Subject: **Revised Permit Modification Request for the Section 404 Individual Permit, Section 401 Individual Water Quality Certification and CAMA Major Permit** for the proposed improvements to US 70 from existing four lanes at Radio Island to north of Olga Road (SR 1426), Carteret County, State Project No. 8.1162501, Federal Aid Project STPNHF-70(43), TIP R-3307. Debit \$570 (NCDWR) and \$100 (NCDCM) from WBS 34528.1.1.

References: Section 404 Permit No. SAW-2010-02125, issued September 27, 2013  
Section 401 Permit No. 3195, issued April 30, 2012  
CAMA Major Development Permit No. 37-12, issued May 3, 2012  
Permit Modification Request, dated September 23, 2014

Please see the enclosed revised permit drawings and impact summary sheet for the above referenced project. Due to a delay in the Duke Energy power line relocation, the contractor has identified the need to construct a temporary ramp to obtain access beyond the power lines to facilitate construction of the temporary work trestle. The temporary ramp will be completely enclosed by approximately 200 feet of temporary sheet pile within wetlands. The majority of the ramp will be constructed on a previously permitted area for

PROJECT REFERENCE NO. R-3307	SHEET NO. 8
RW SHEET NO.	
ROADWAY DESIGN ENGINEER	HYDRAULICS ENGINEER
Permit Drawing Sheet 5a of 34 Revised 16 Dec 2015

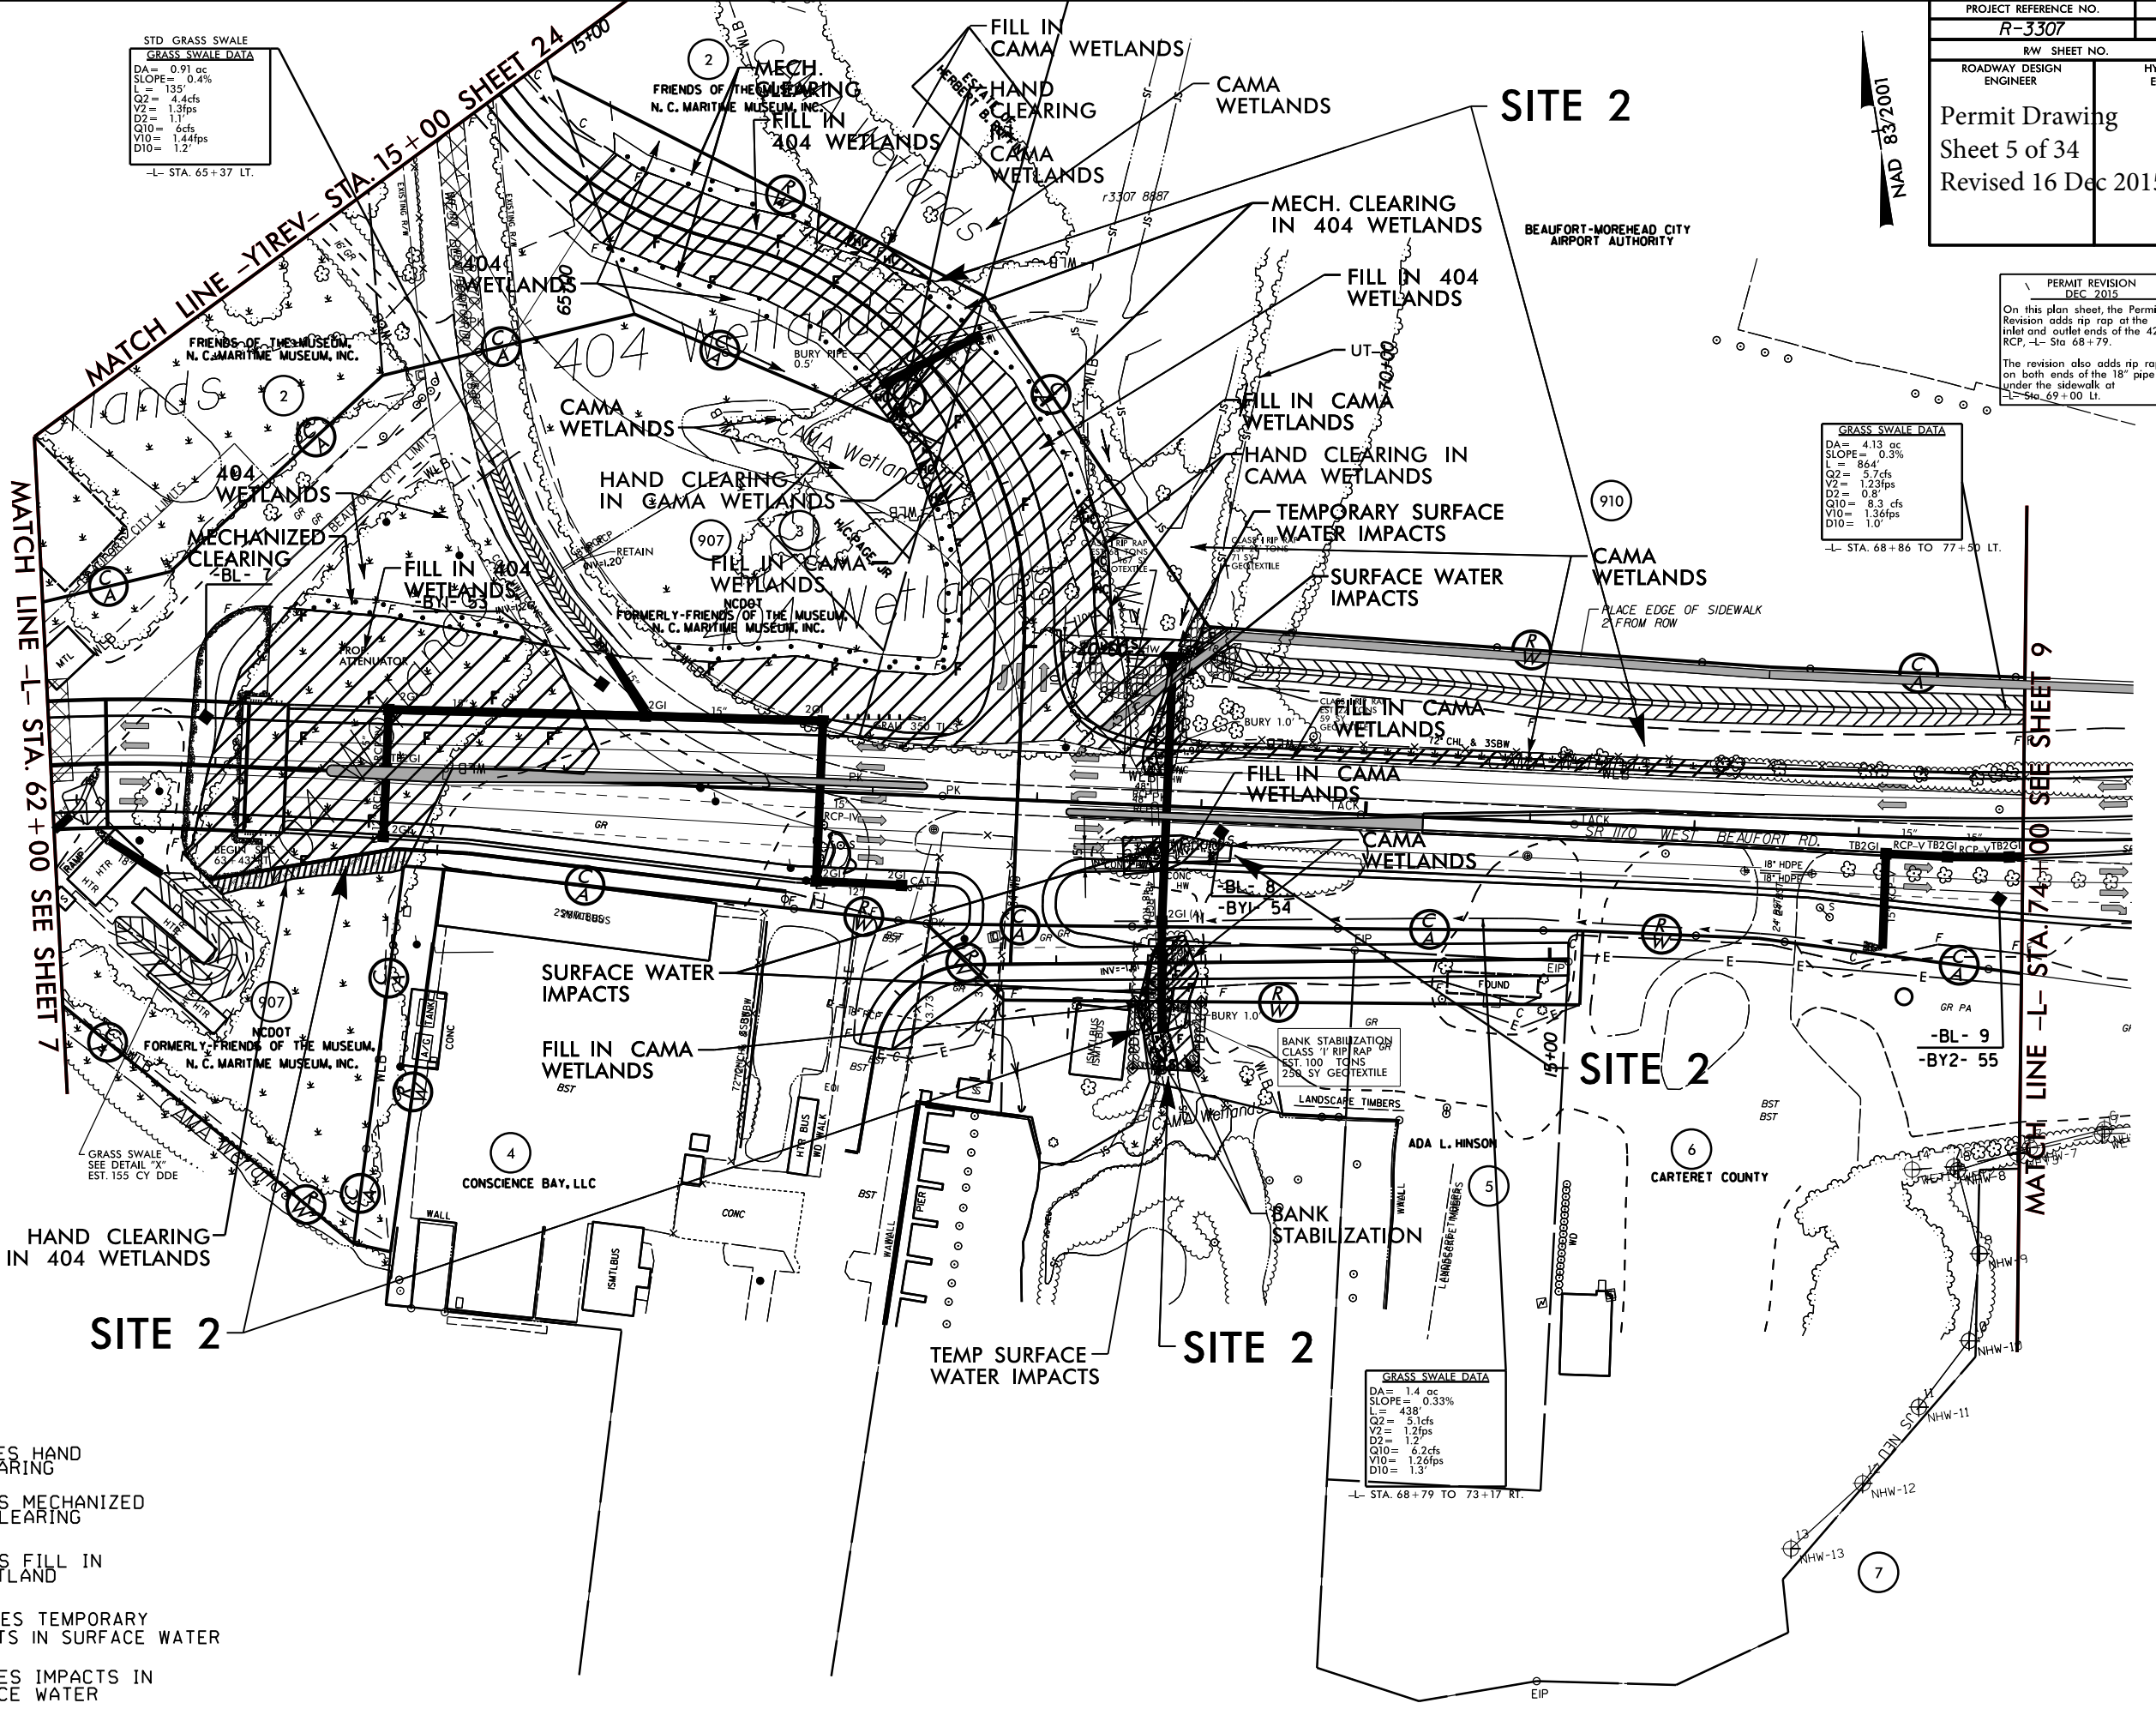
Please note, a revision has been made on permit drawing sheet 5 (plan sheet 8, -L- Sta. 63+43). The original permit drawings erroneously illustrated the fill within the retaining wall at the approach. This has been corrected, resulting in a 0.01 acre impact increase to 404 wetlands at site 2.
